**KIRKLEES METROPOLITAN COUNCIL  
INVESTMENT & REGENERATION SERVICE**

**DELEGATED DECISION TO DETERMINE PLANNING APPLICATIONS**

Reference No:	<b>2023/62/90339/E</b>
Site Address:	28, Fir Parade, Ravensthorpe, Dewsbury, WF13 3BH
Description:	Erection of single and two storey side and rear extension
Recommending Officer:	Edward Cheseldine

**DECISION - REFUSED**

28, FIR PARADE,  
RAVENSTHORPE,  
DEWSBURY.

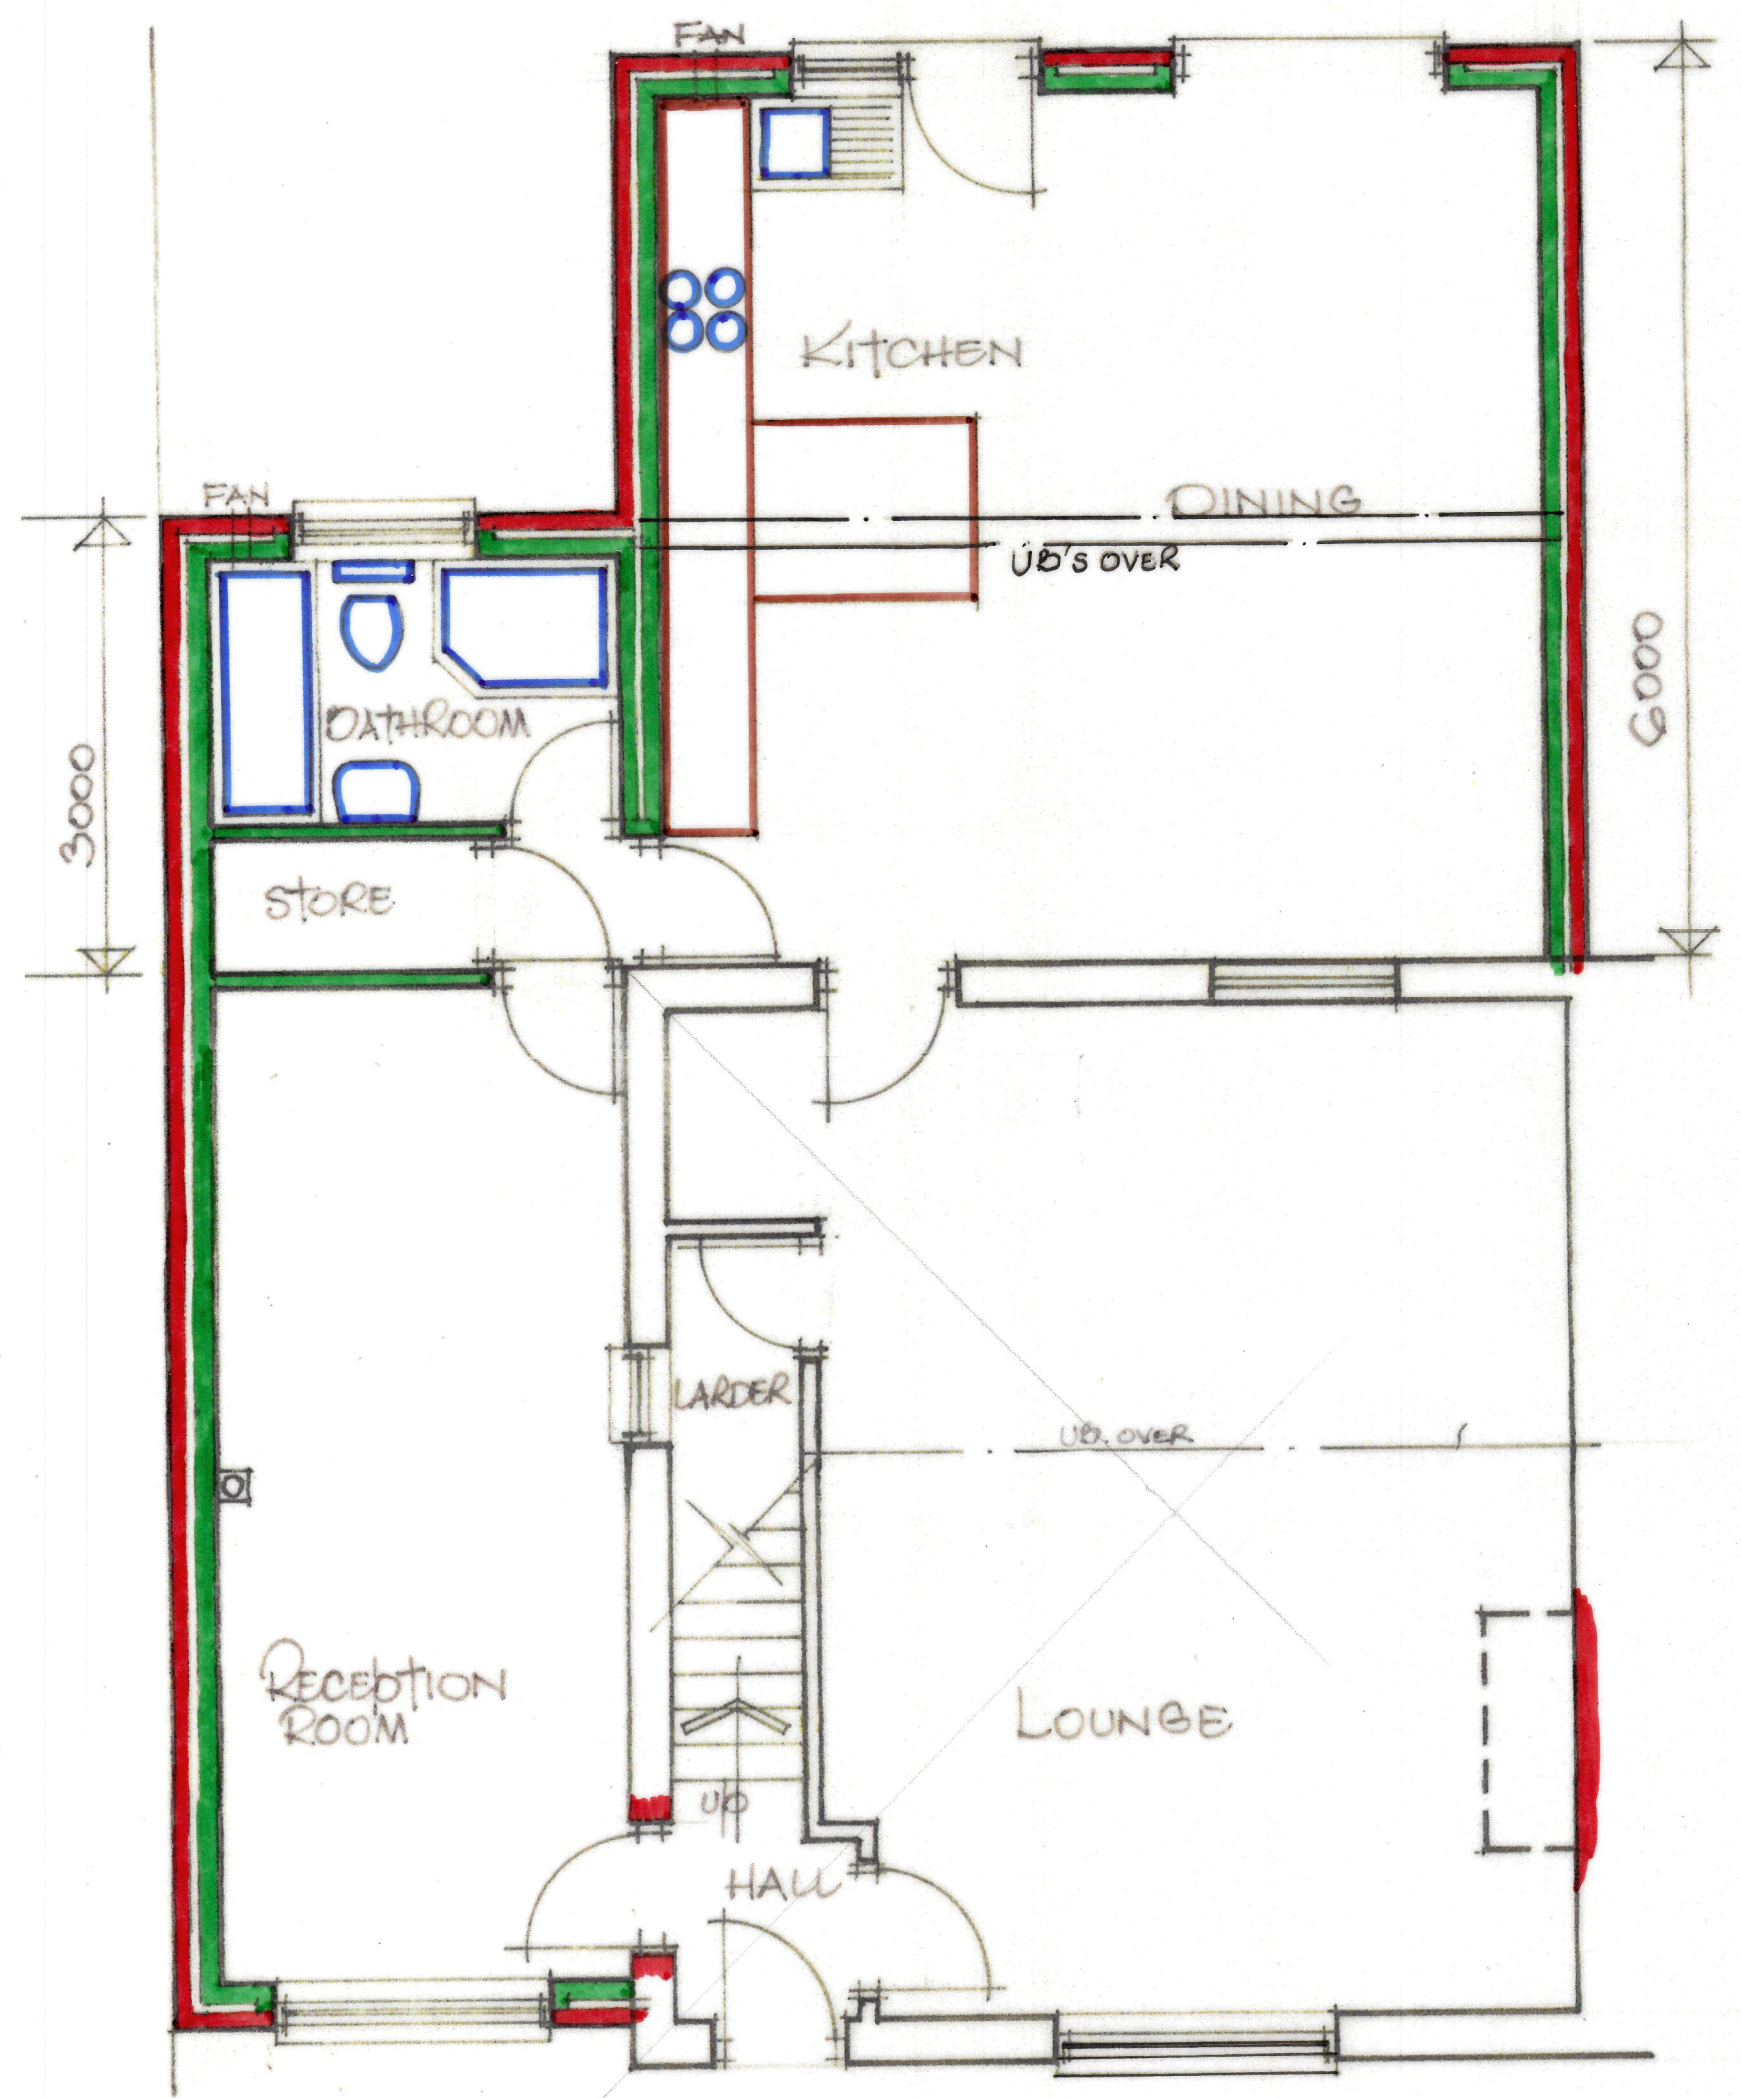
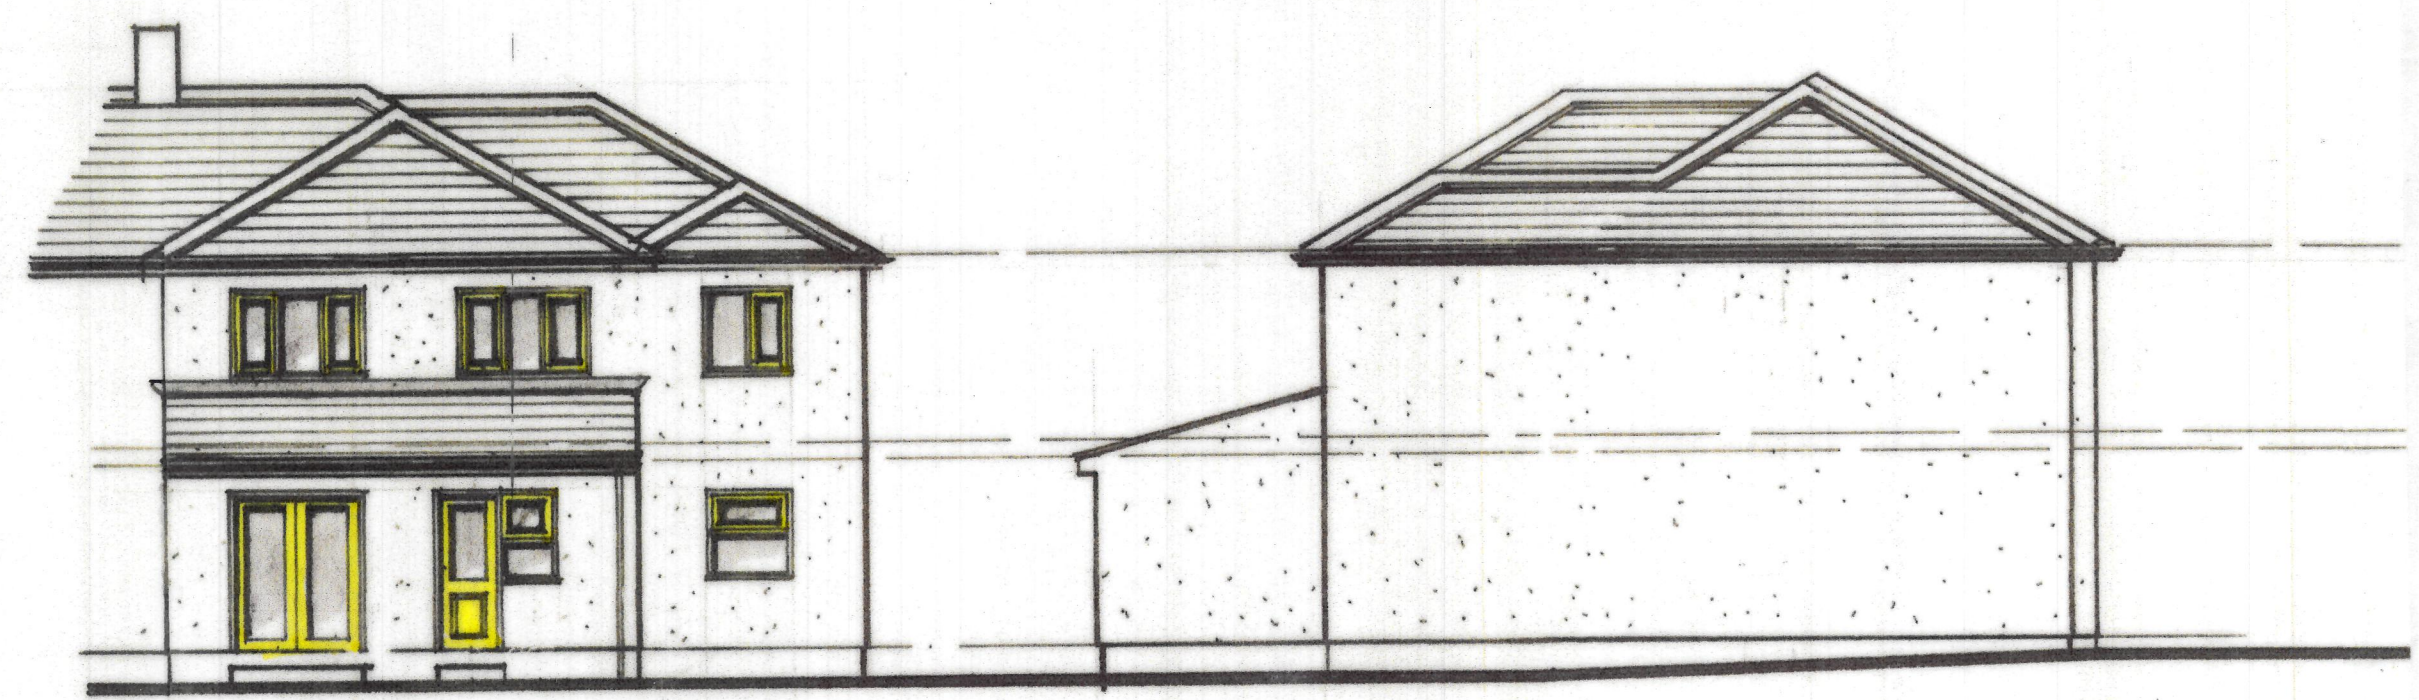
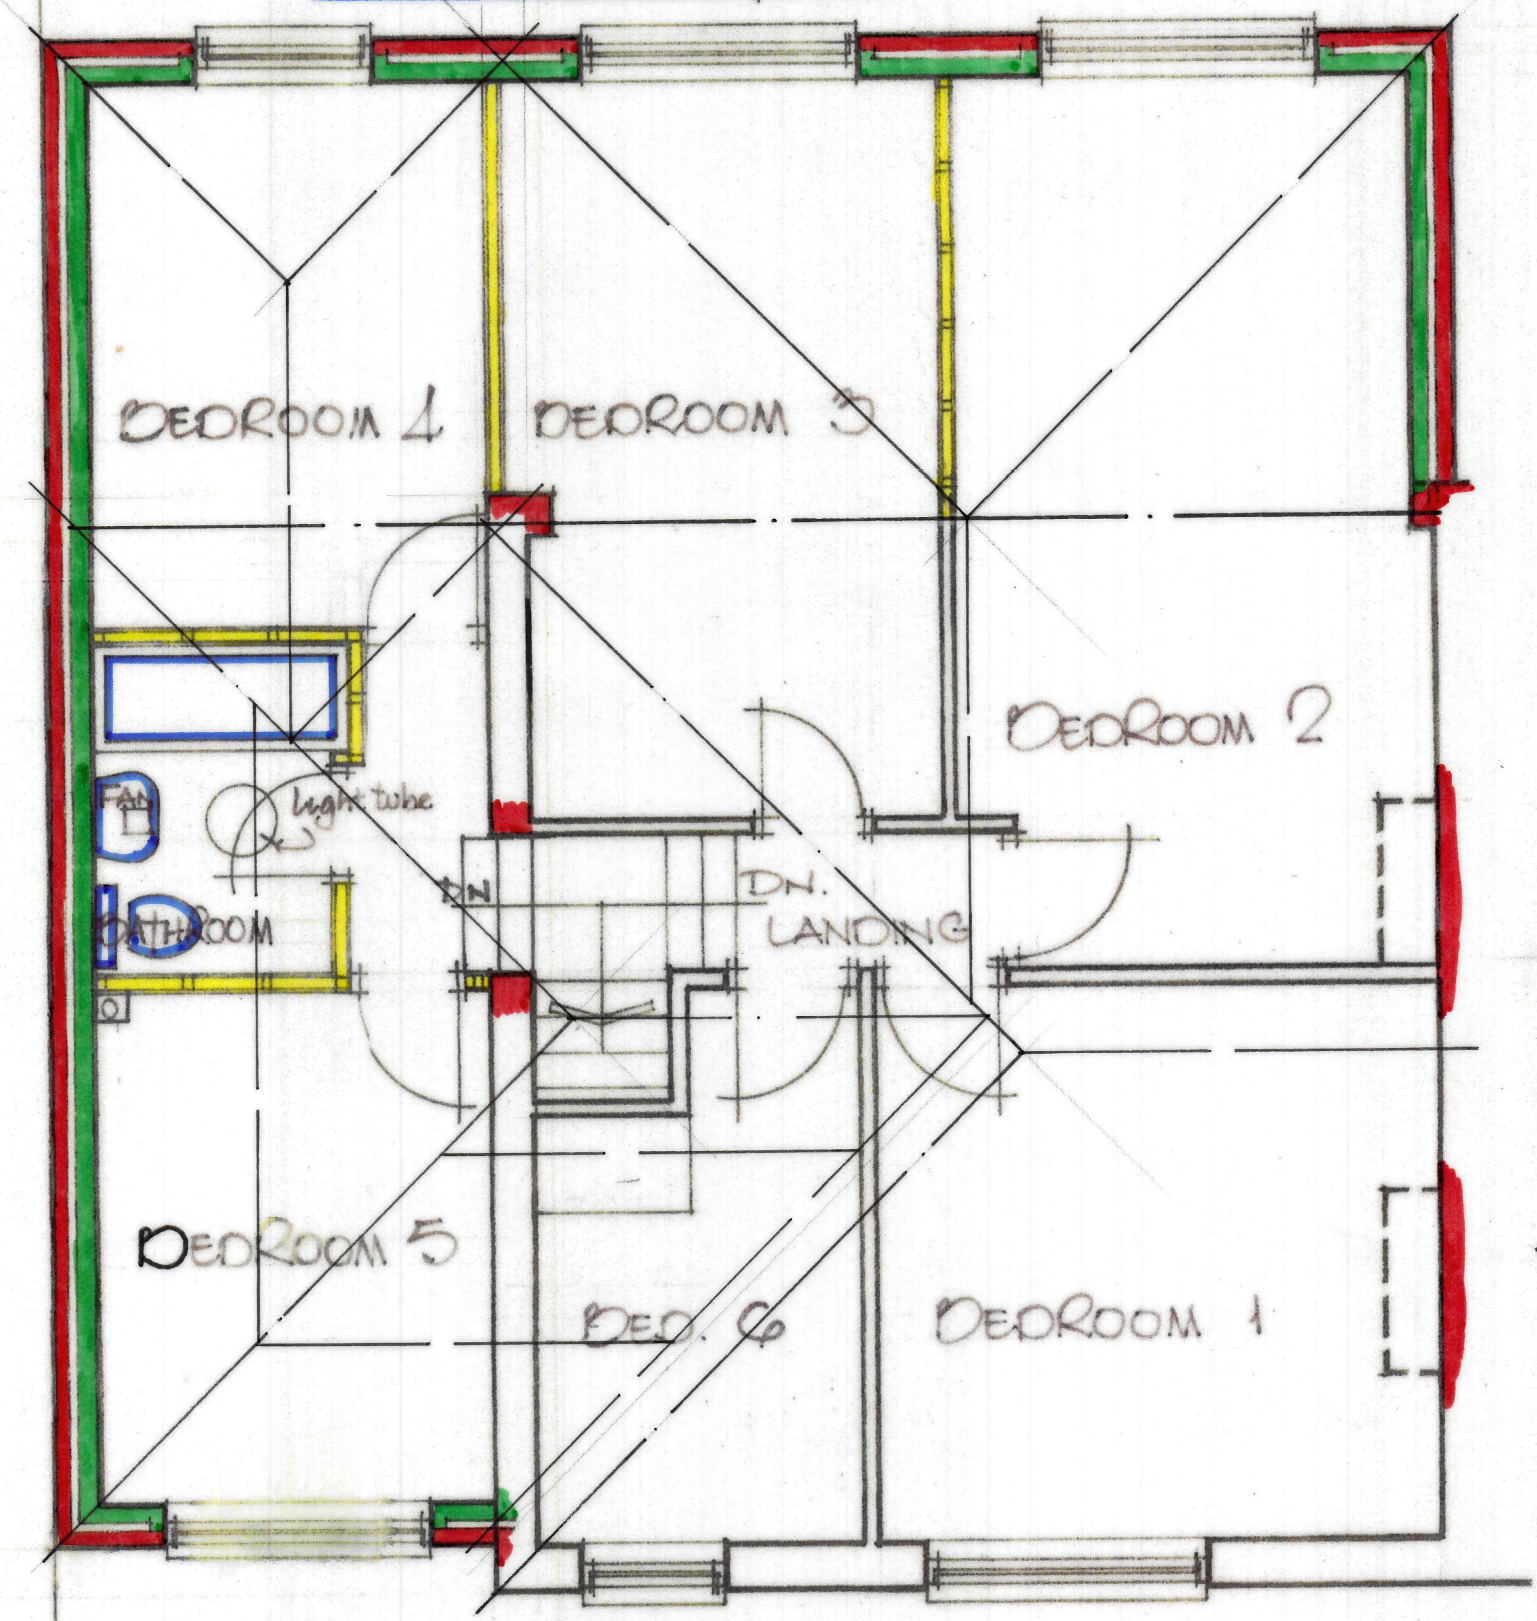
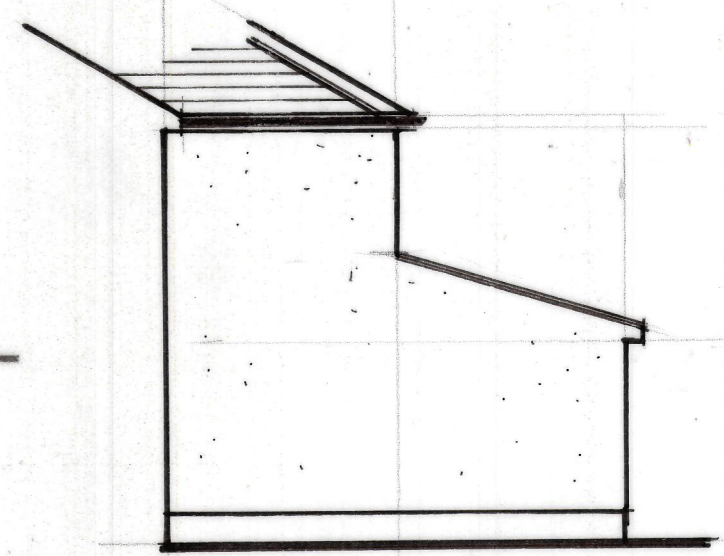
These guidelines have not been met as a 1 metre gap to the side boundary has not been retained. Thus the development would appear cramped within the plot, creating the present for a terracing effect within the street. As per paragraph 1.9 - 1.11 of the House Extensions & Alterations SPD, a justification for development has been sought, as the development does not comply. After contacting the applicant there has been no justification or amendment complying with the House Extensions & Alterations SPD.

In terms of scale, a footprint of 9.4m (W) x 6.0m (L) is not subservient to the host dwelling and covers an area that is over half of the original house. In this instance, prior approval has been granted for a 6.4m x 6.0m single storey rear extension at this property under application 2023/90311 which can be afforded weight in the decision-making process. The two-storey extension matches the eaves of the existing building, given this and application 2023/90311 the scale is deemed acceptable. A 1.5-meter boundary between the extension and property boundary will not be kept. The position of the ground floor rear extension has been granted prior approval under 2023/90311 and in this instance can be afforded weight in the decision-making process making the proximity to the boundary acceptable. In terms of the first-floor, the extension spans the entirety of the existing dwelling, as such, the structure would obtrude to the property line which therefore does not leave a gap of at least 1.5m. The effect of this, in relation to the habitable room/window of the adjoining property will be dealt with in the residential amenity section below.

Having considered the above factors, the proposals are considered to result in a significant, adverse impact upon the visual amenity of the streetscape by none retention of a 1.0m gap to the property boundary and does not comply with Policy LP24 of the Kirklees Local Plan (a) & (c) as well as guidance set out in the Extensions & Alterations SPD and Paragraph 130 (f) of the National Planning Policy Framework.

No. 26 is situated to the east of the application and is the adjoining semi-detached property. In terms of privacy, there are no additional openings facing No. 26. Furthermore, the extension could overbear No. 26 impacting a 45° outlook of habitable windows and leading to a loss of light / sunlight to the neighbouring property, as the rear extension extends to the property boundary. As per paragraph 1.9 - 1.11 of the House Extensions & Alterations SPD, a justification for development has been sought, as the development does not comply. After contacting the applicant there has been no justification or amendment complying with the House Extensions & Alterations SPD.

No. 30 is situated to the west of the application and is the adjacent dwelling. In terms of privacy, there are no additional openings facing No. 30. Furthermore, the extension could overbear the neighbouring property at No.26, however the general scale and height of the development in being located along the entire boundary is not conducive to quality of accommodation for the occupant's amenity space due to appearing overbearing and therefore contrary to policy.

1. The two-storey side extension by way of projection, height and proximity to the property boundary, would appear cramped within the plot and would precipitate a terracing effect in the street scene, detrimental to visual amenity and character of the area and be contrary to policy in the Kirklees House Extensions and Alterations Supplementary Planning Document, Policy LP24 of the Kirklees Local Plan and Chapter 12 of the National Planning Policy Framework.
2. Due to the height and location along the boundaries, the extension would result in an overbearing impact on neighbouring occupants thereby detrimental to private amenity and be contrary to policy in the Kirklees House Extensions and Alterations Supplementary Planning Document, Policy LP24 of the Kirklees Local Plan and Chapter 12 of the National Planning Policy Framework.
